Active
Travel
England

Your Ref: 23/01496/DISC 23/01558/DISC 23/01493/REM 23/01586/REM
Our Ref: ATE/23/00163/XCOND
ATE/23/00162/XCOND
ATE/23/00156/RM
ATE/23/00153/RM
Date: 11 July 2023

Active Travel England Planning Response Detailed Response to an Application for Planning Permission

Site Address: PROPOSED HIMLEY VILLAGE NORTH WEST BICESTER,
MIDDLETON STONEY ROAD, BICESTER, OX26 1RT

STRATEGIC SECONDARY ROAD

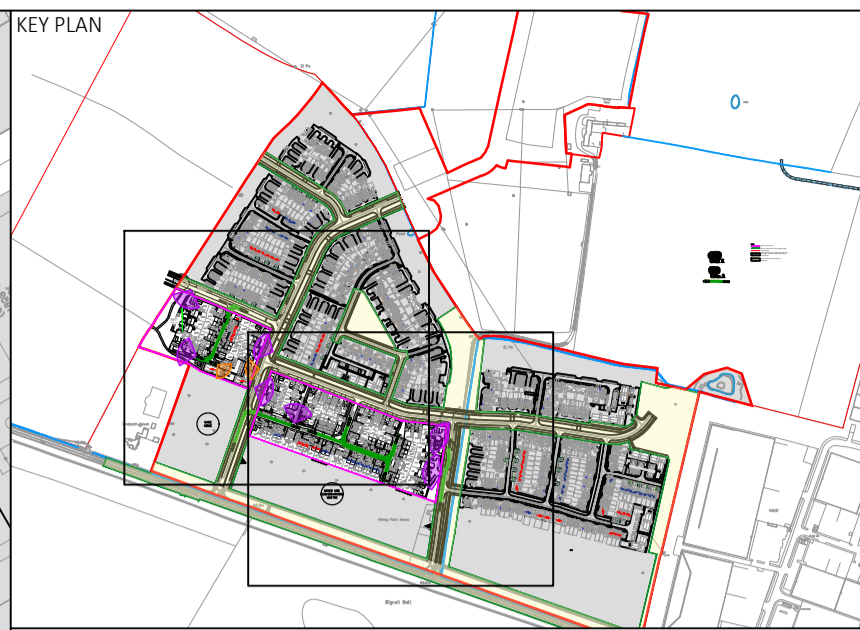
- There are currently two main accesses proposed into and out of the site from the B4030 which will also serve as the primary routes in and out for pedestrians and cyclists. Several additional future potential links have been identified but will not come forward as part of these proposals. To guarantee active travel permeability, connections 3 and 4 shown on Figure 3 Proposed Vehicular Access Points of Design Code Part 4 (23/01496/DISC) should be secured by condition and should not be reliant on vehicular routes coming forward. This would allow for pedestrian and cycle access to newly developed employment areas and other key services by avoiding busy roads.

HIMLEY VILLAGE, BICESTER - PHASE 2A - BOUNDARY TREATMENTS PLAN

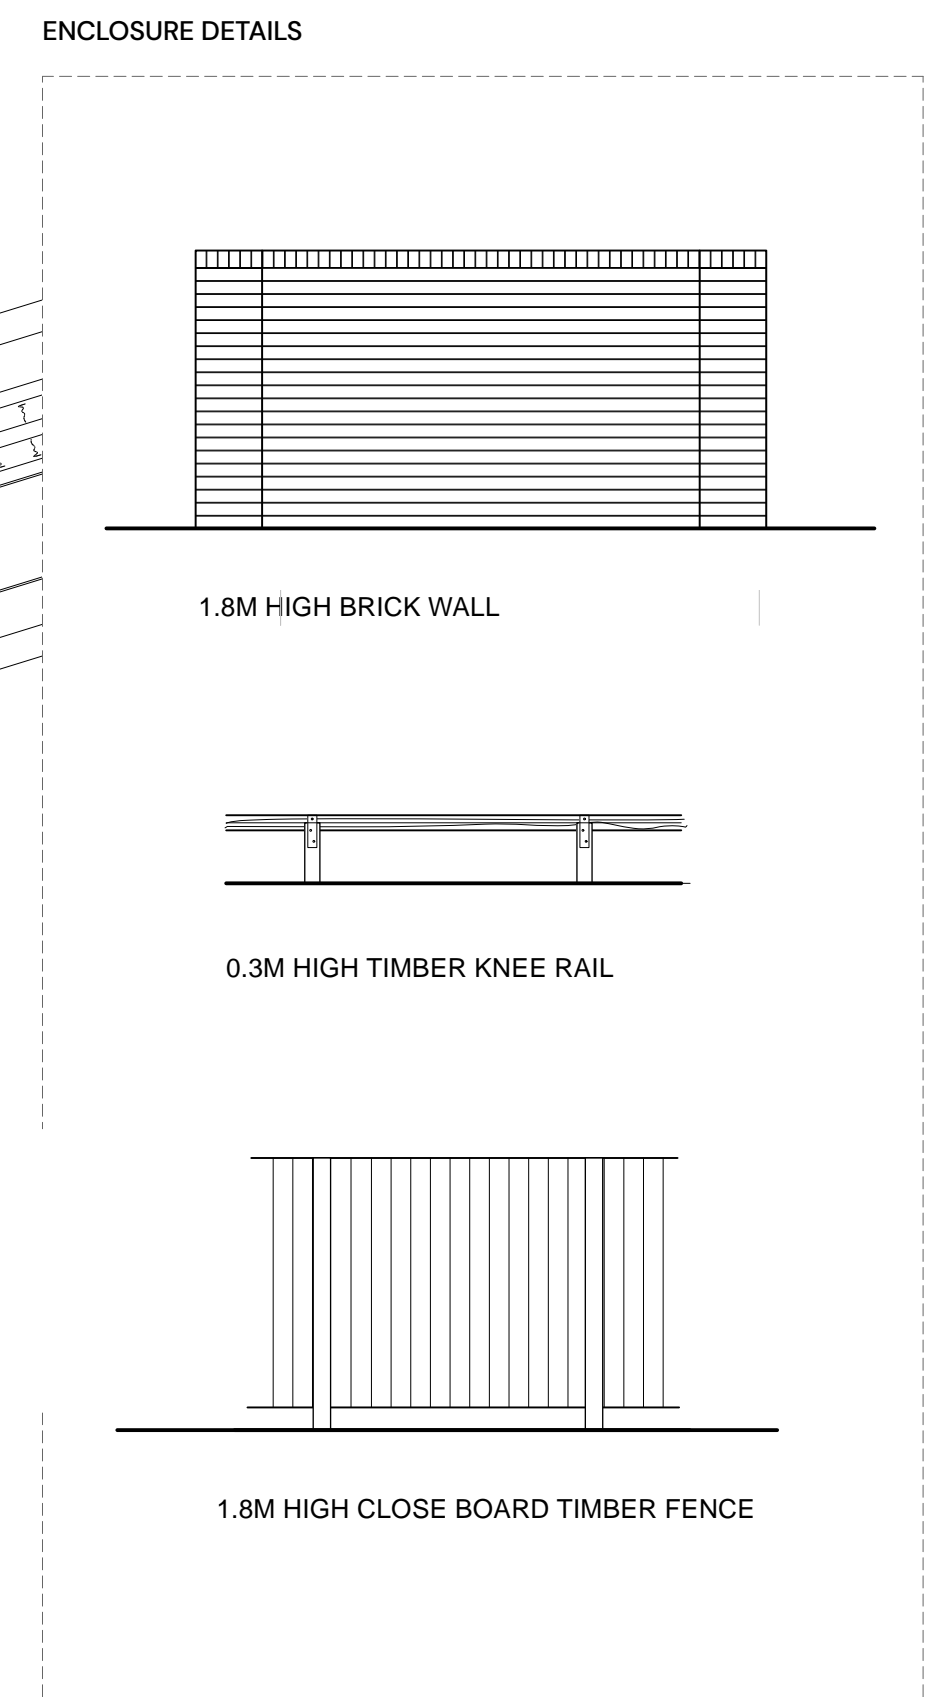
Further, cycle parking spaces should be easily accessible in accordance with Para 106 d) of the NPPF. Sheds in rear gardens which require the cycle to be brought through the dwelling are inconvenient and should be avoided in favour of secure shelters to the front of dwellings which allow easy access to the active travel network.
